FP/86/11/NMA²

Application for a non-material amendment following a grant of planning permission.

NON-MATERIAL AMENDMENT FOLLOWING A GRANT OF PLANNING PERMISSION FP/251/07 TO INCREASE BUILDING HEIGHT OF BLOCK D, PLOTS 88-98 NOW KNOWN AS PLOTS 237-247 WITHIN PHASE 2 - SITE 6, FELPHAM.

INCREASE IN GROUND TO FIRST FLOOR F.F.L. OF SINGLE APARTMENT GRANTING ACCESS TO REAR PARKING COURT.

Drawing Title:
FLAT TYPE D
AFFORDABLE
ELEVATION SHEET2

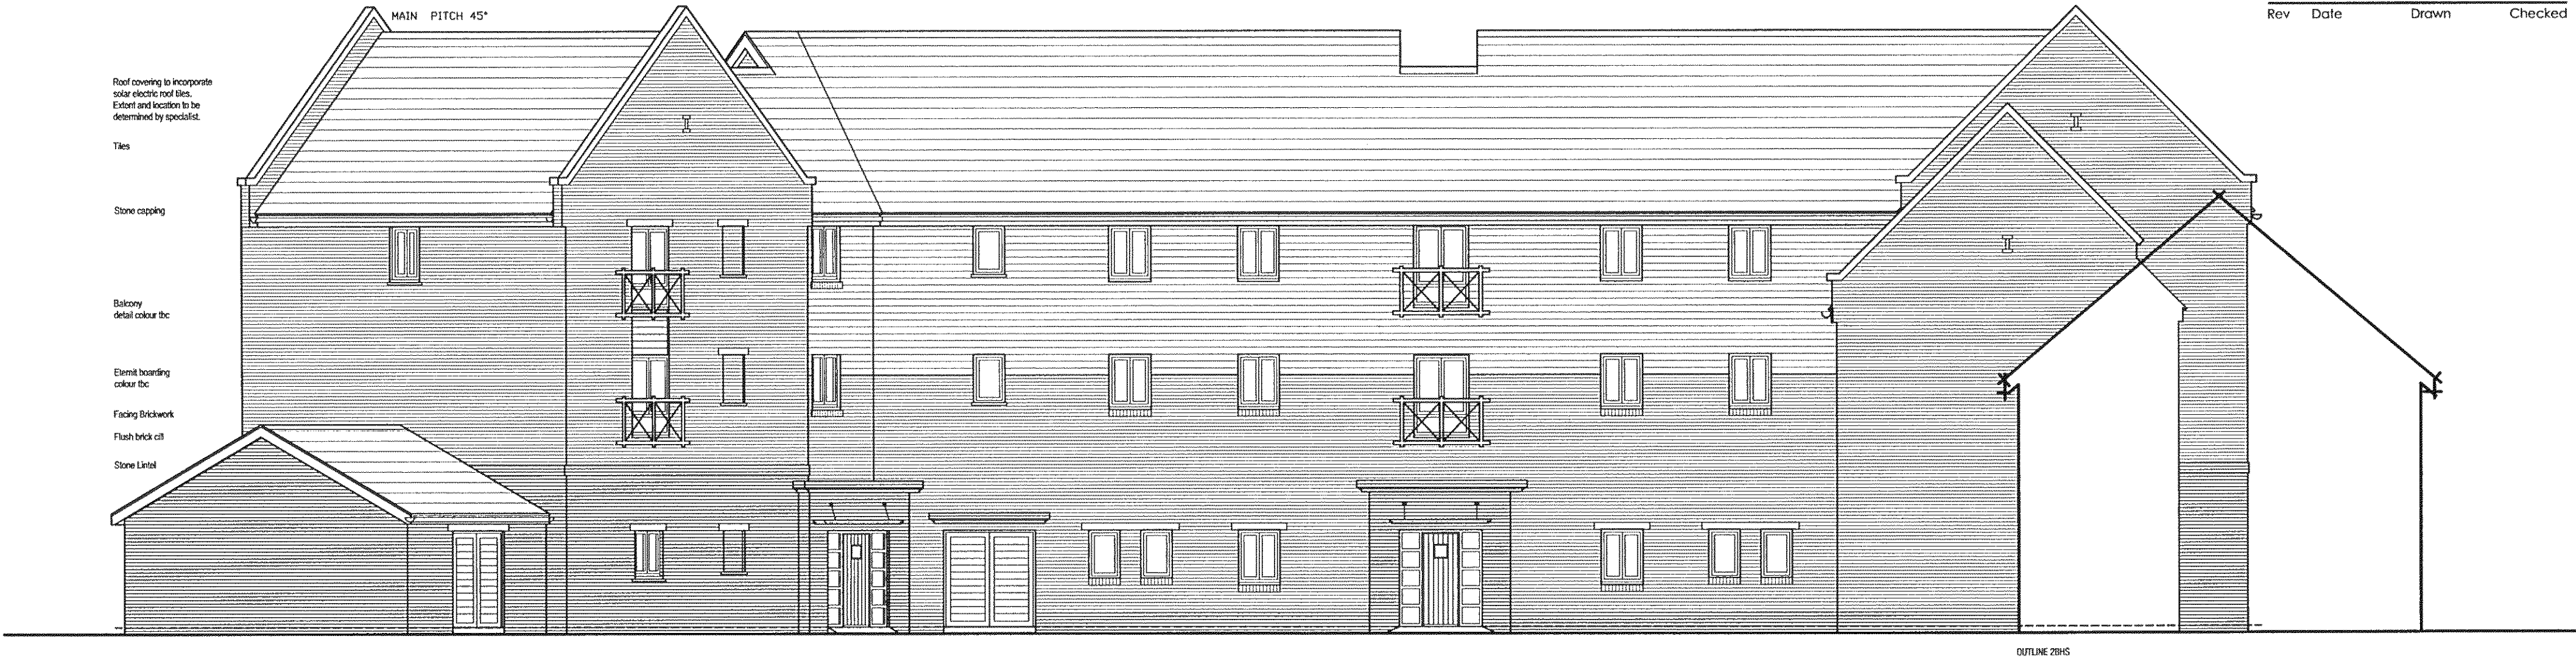
TO PROVIDE REQUIRED CLEARANCE HEIGHT OF 3.7M TO ENABLE FIRE APPLIANCE ACCESS TO THE REAR OF THE BLOCK.
